From: Contact Centre (CRM) <contact@ribblevalley.gov.uk>
Sent: 16 July 2022 18:19
To: Planning
Subject: Planning Application Comments - 3/2022/0622 FS-Case-437504355

Planning Application Reference No.: 3/2022/0622

Address of Development: The old corn mill warwick street Longridge PR3 3EB

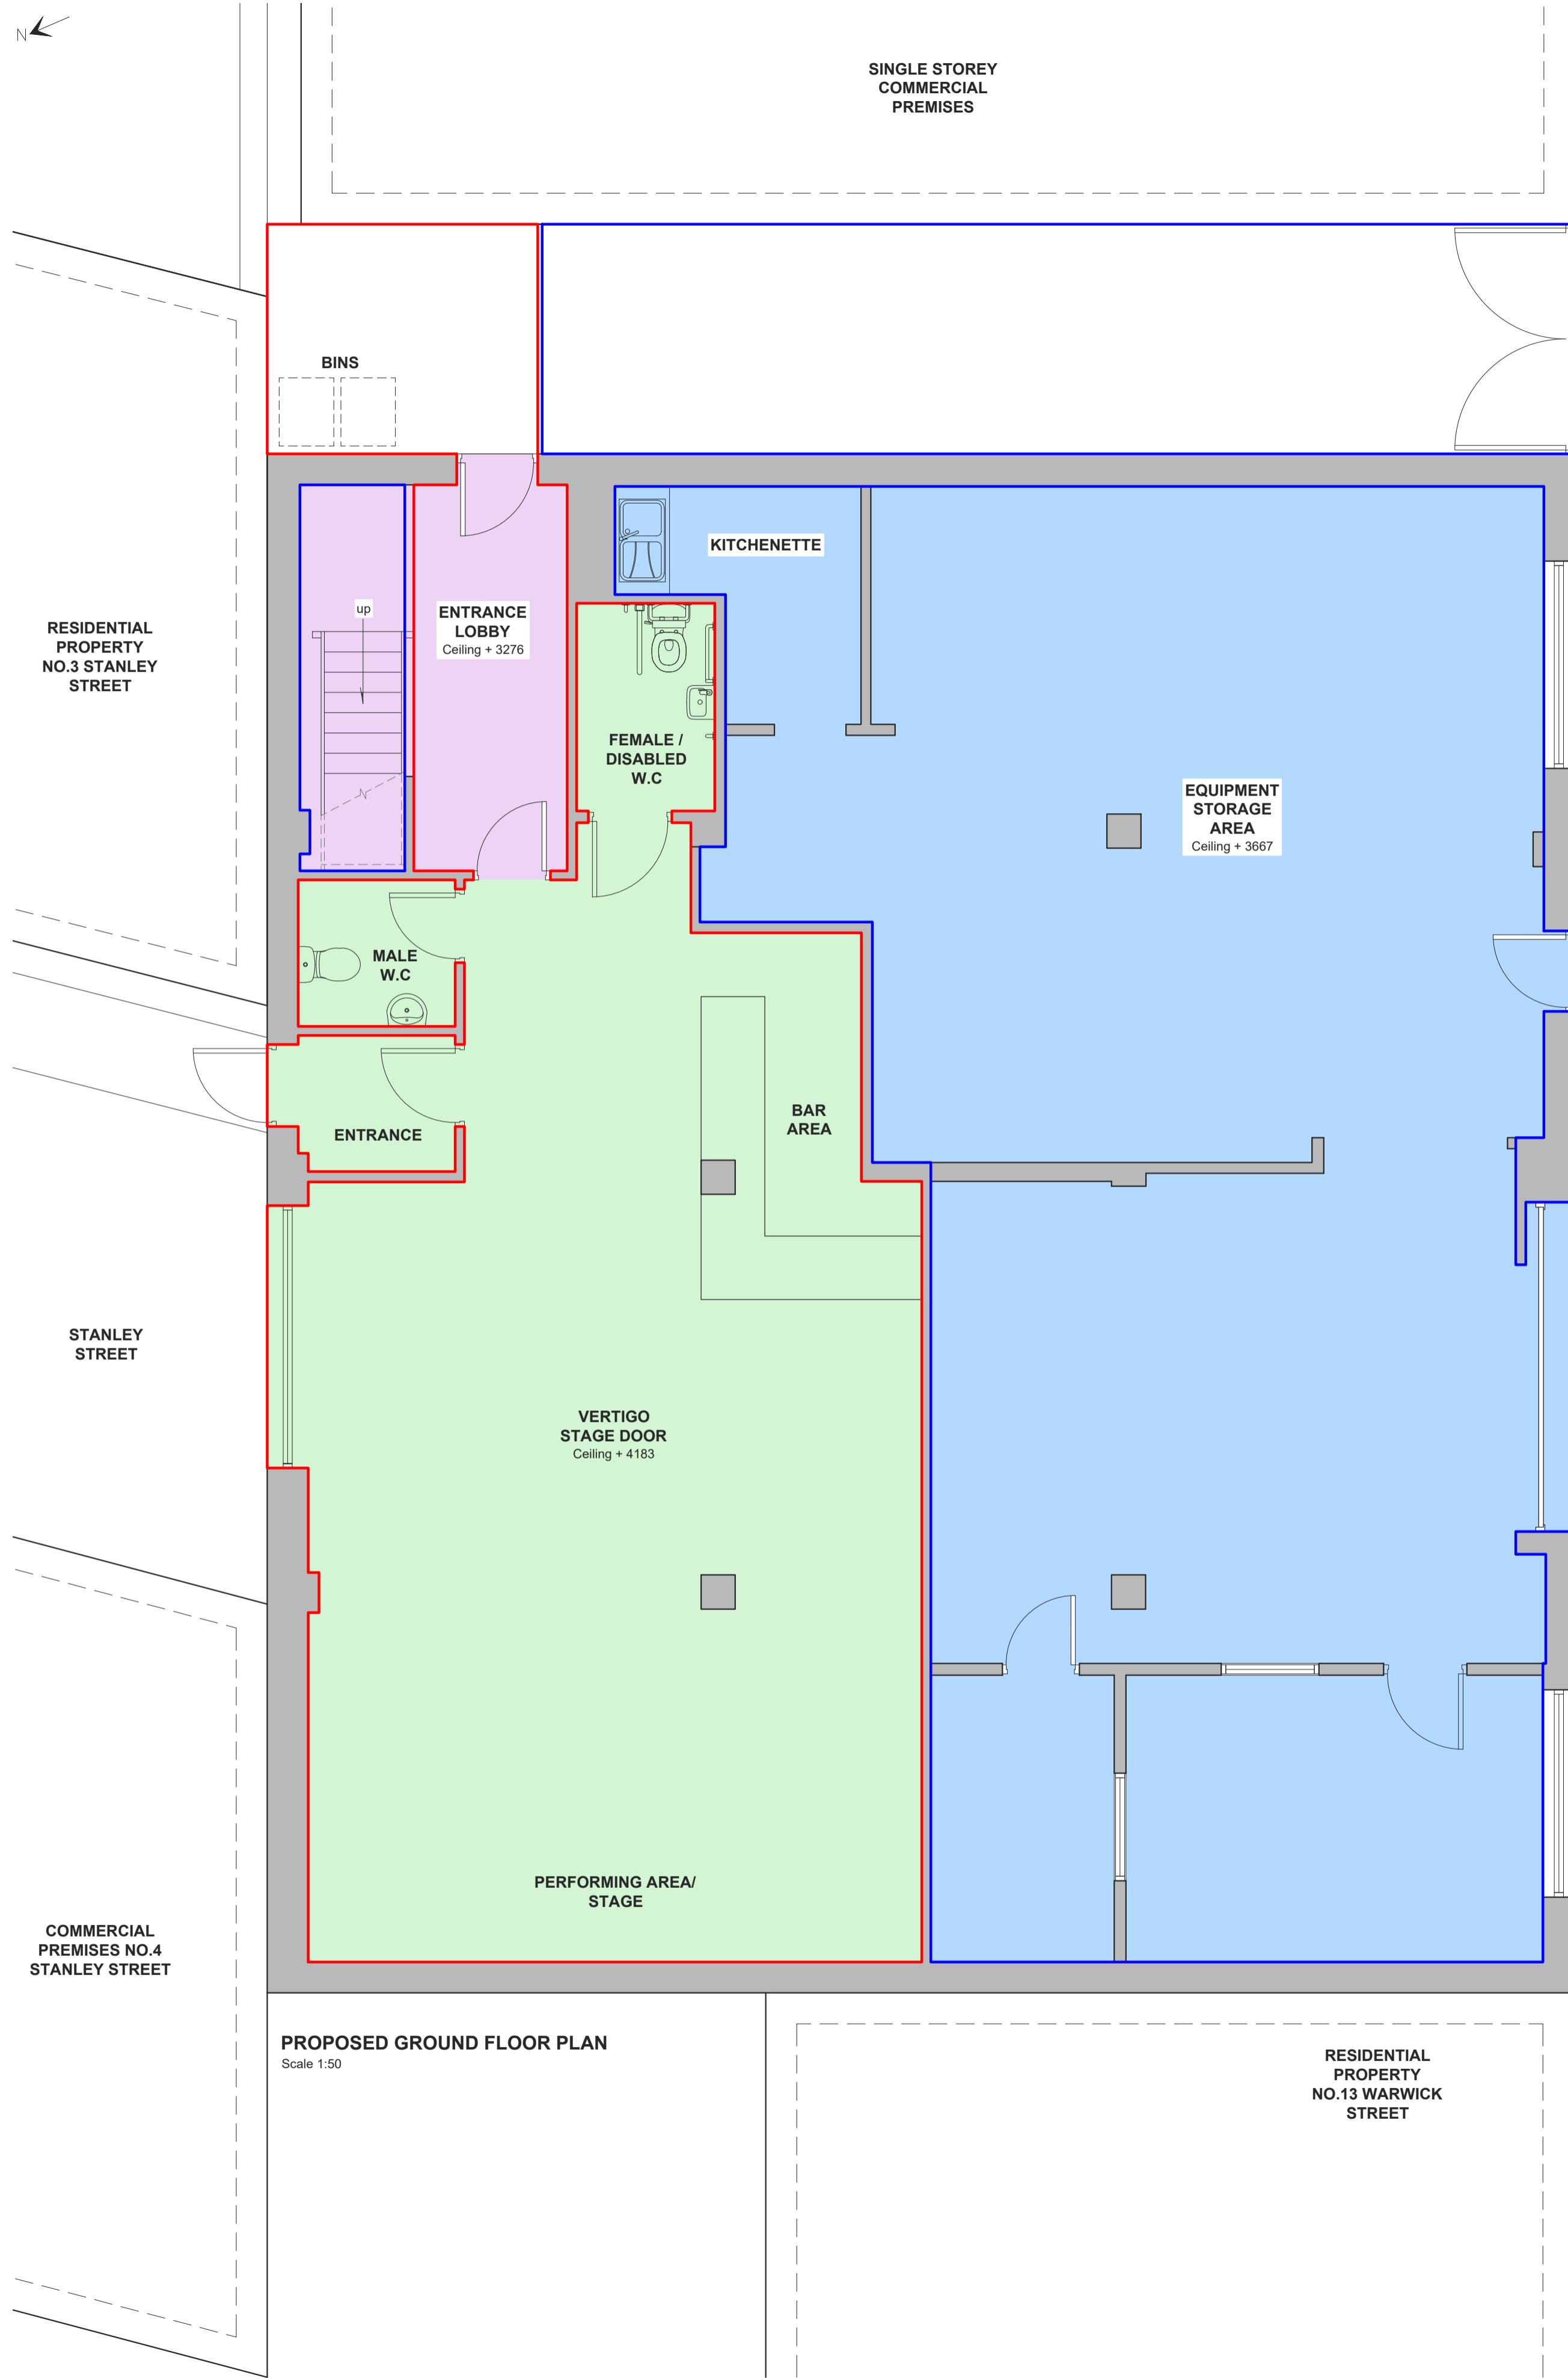
Comments: I dont appose to the venue i appose to the access to the venue! RE the residential and the emergency access to the building!!
